TR010062: Application by National Highways for the A66 Northern Trans- Pennine Project
The Examining Authority's Further Written Questions and requests for information
Issued on Friday 24 March 2023

The following table sets out the Examining Authority's (ExA's) Further Written Questions and requests for information, herein referred to as FWQs.

Drawing Title: Classification of Roads Plan Regulation 5(2)(o) Sheet 1 of 2

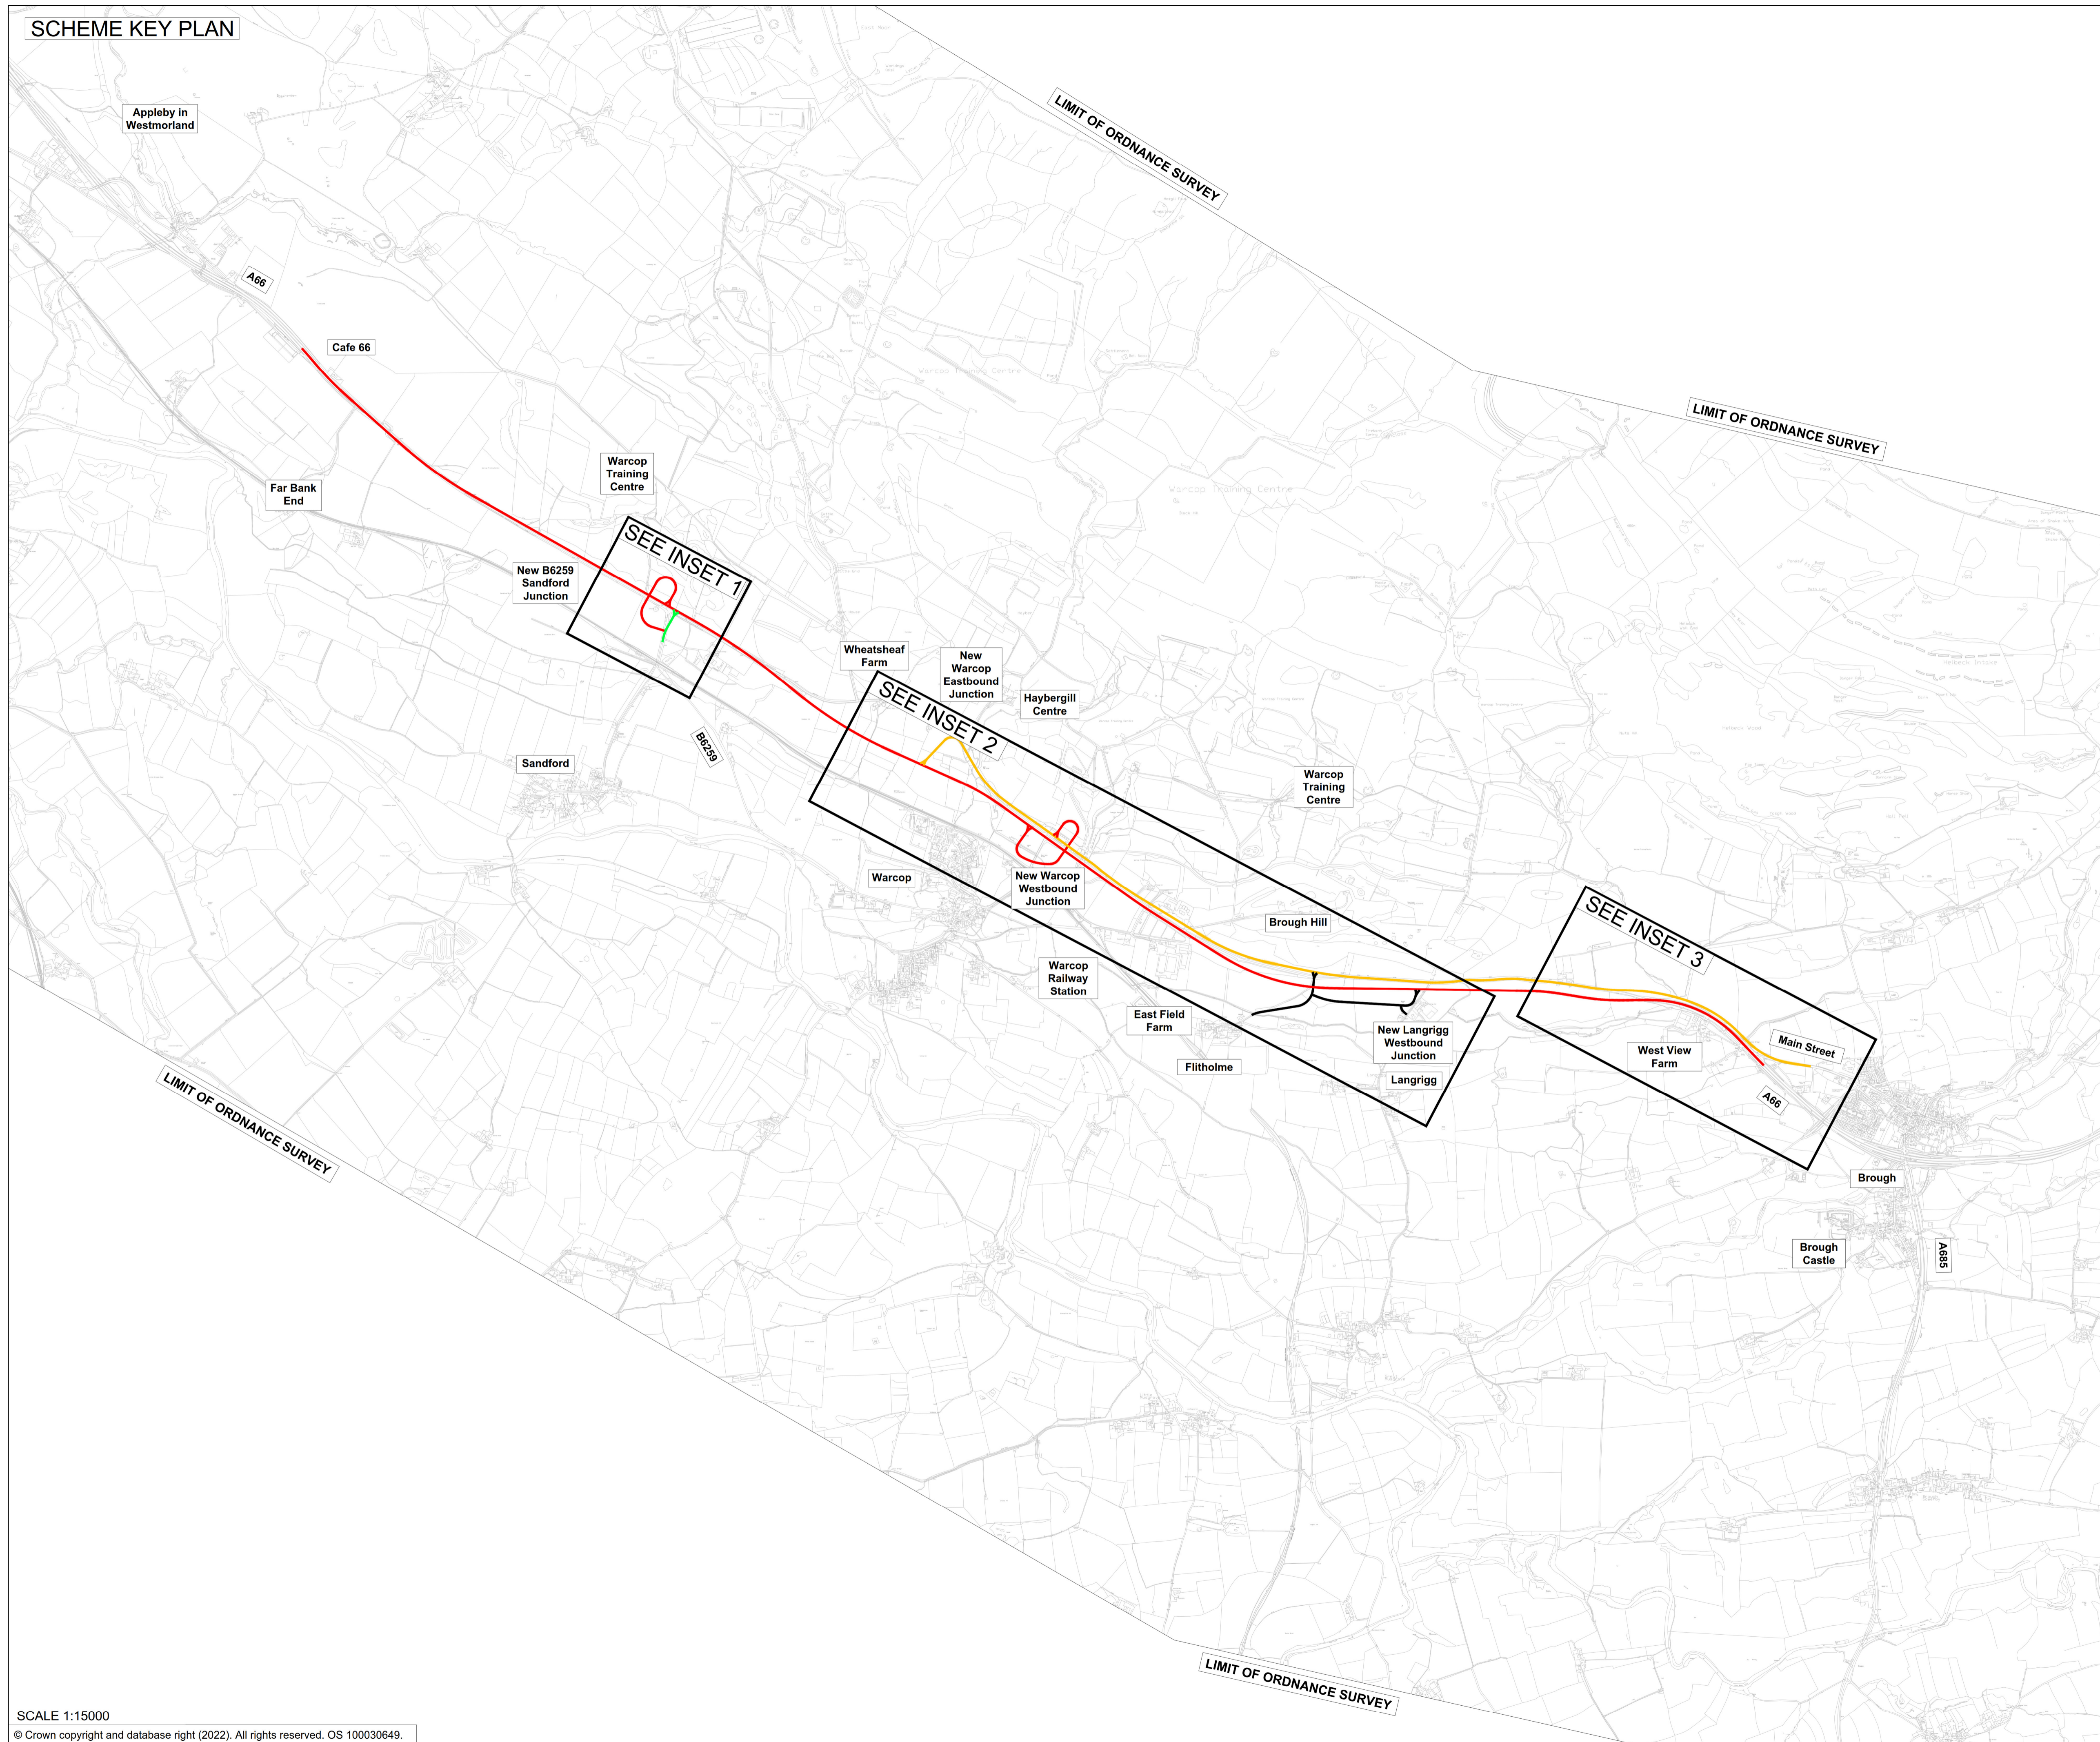
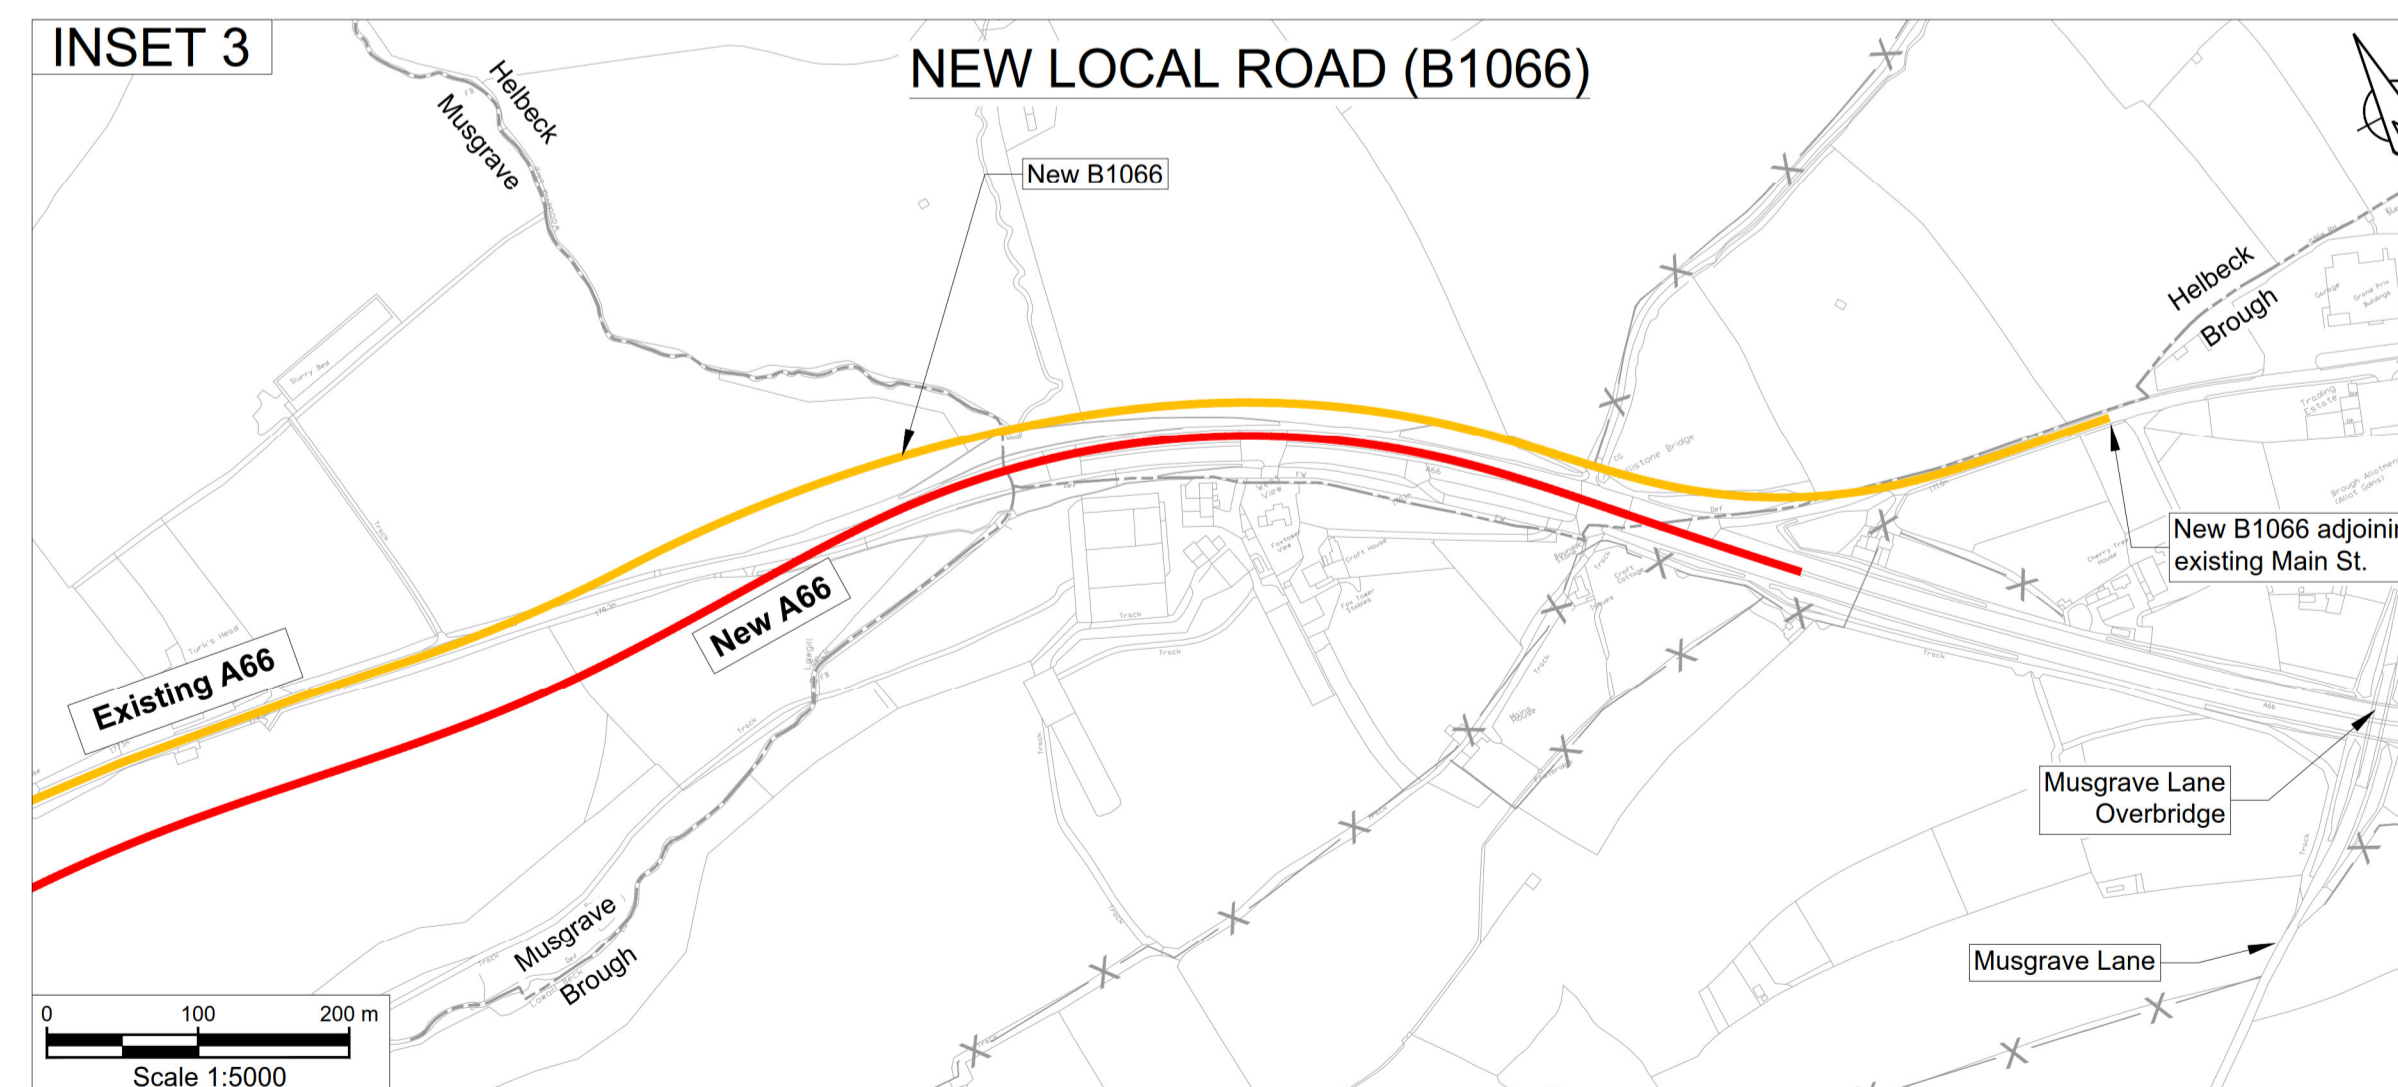
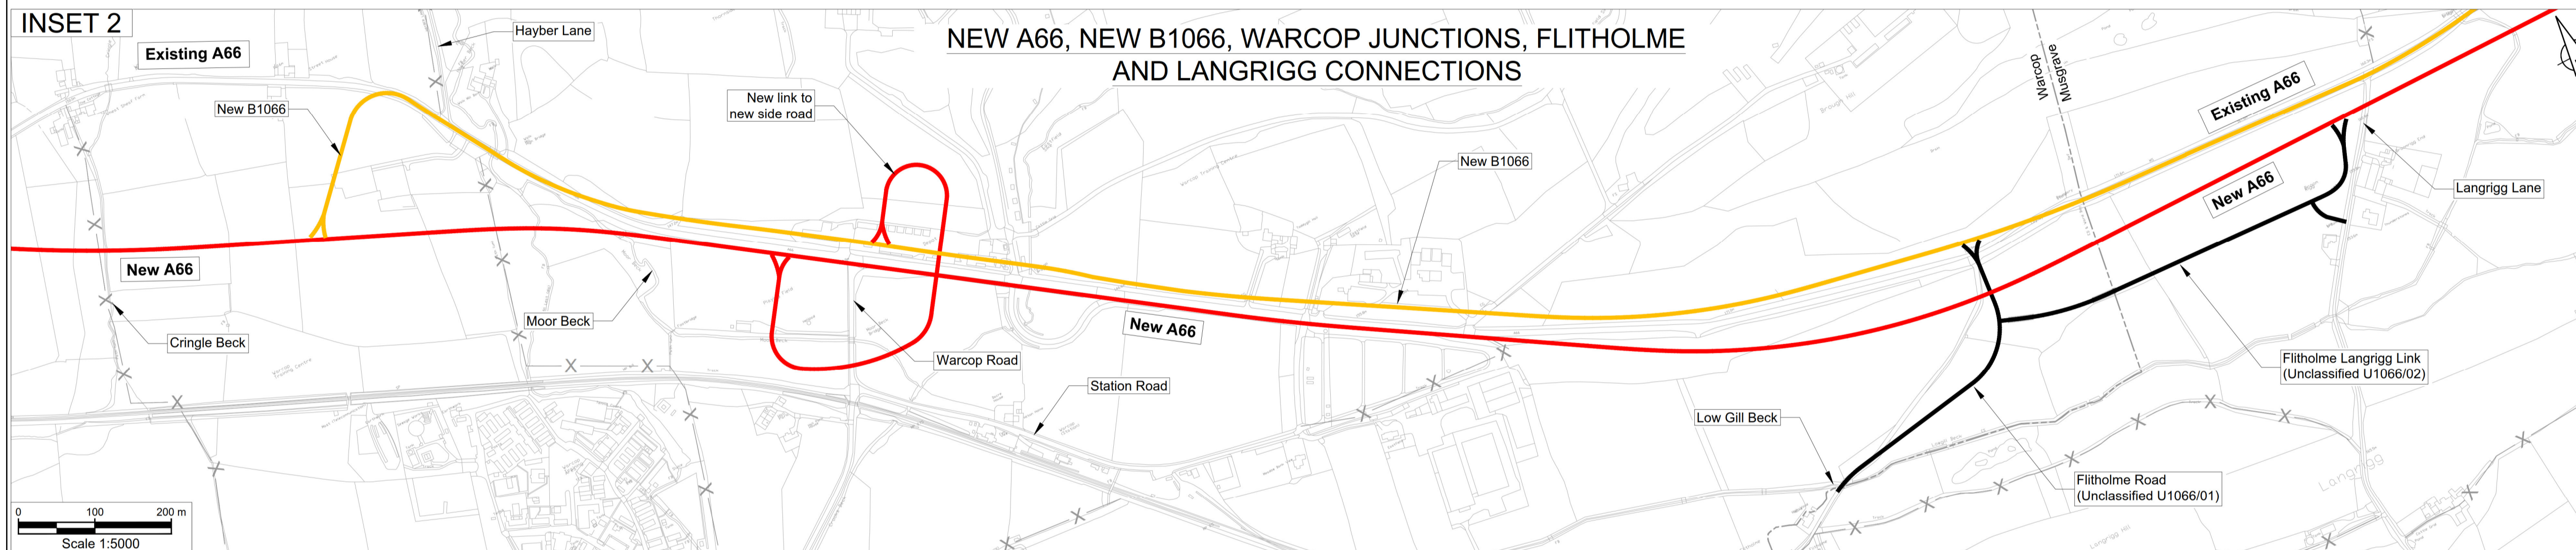
DCO 2.3	<p><i>Schedules 2 and 7</i> The Applicant</p>	<p>In its response [REP1-005] to the ExA’s Supplementary Agenda Additional Question ISH2.DCO.18 [EV-004], the Applicant suggested that the classification number to the de-trunked section of the A66 should be unique and is under discussion with Cumbria CC. The latest draft DCO [REP5-012] still refers to the B1066, which is not a unique classification number. Explain why this has not been amended.</p>
